Re: Proposed development of a resource recovery centre (including waste-to-energy facility)
in Ringaskiddy, County Cork.

I have been asked by An Coimisiún Pleanála to refer further to the above-mentioned proposed development which is before the Commission for consideration, and, in particular, to the further information submitted by you to the Commission dated 31st August 2026.

Please be advised that the Commission, in accordance with section 37F(1)(a) of the Planning and Development Act 2000, as amended, hereby requires you to furnish the following further information in relation to the proposed development:

Figure 3 Comparison of predicted and measured cliff retreat for the period 2008 to 2025 for each of the cross-sections assessed

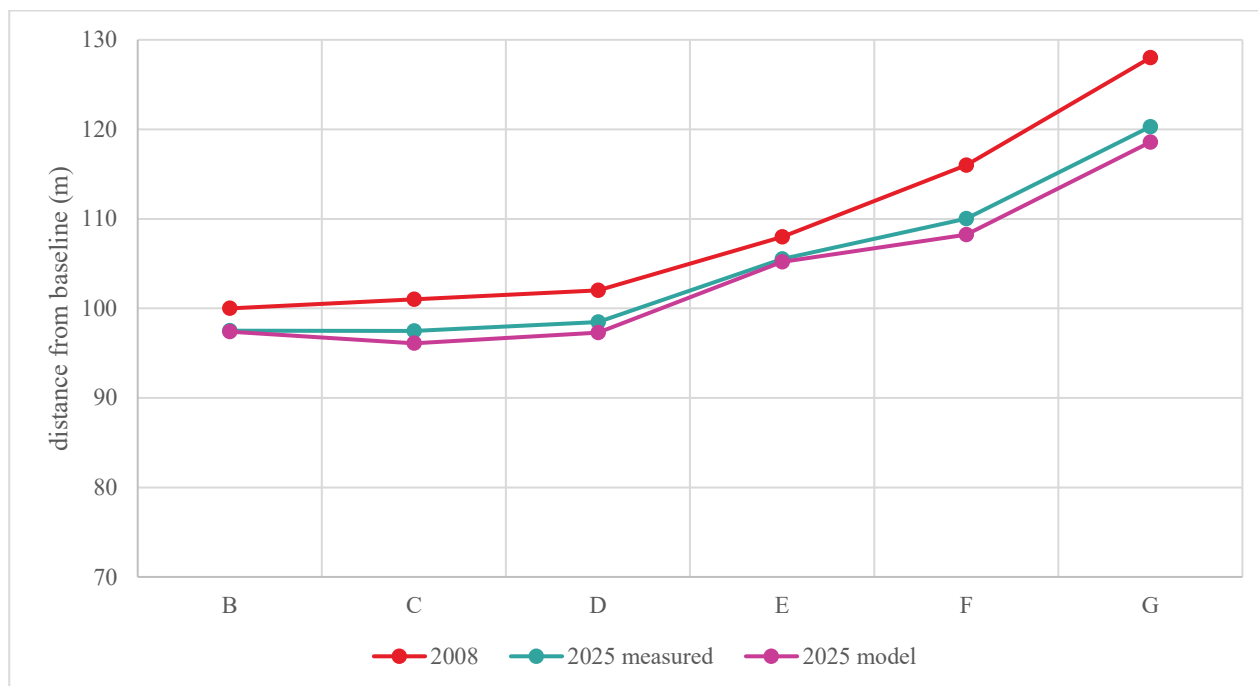
2. Following receipt and consideration of the document 'Updated Coastal Recession Assessment – 2026' contained at Appendix I of Attachment 7.2 of your further information submission, you are requested to clarify the following:

- (i) The version of the SCAPE model used as part of the assessment.
 - (ii) The wave and water level conditions used during the calibration period from 2008 to 2025 (Section 3.2.4 refers).

- (iii) Calibrated 'R' values, where 'R' relates to material strength and some hydrodynamic constants (Section 3.2.4 refers).
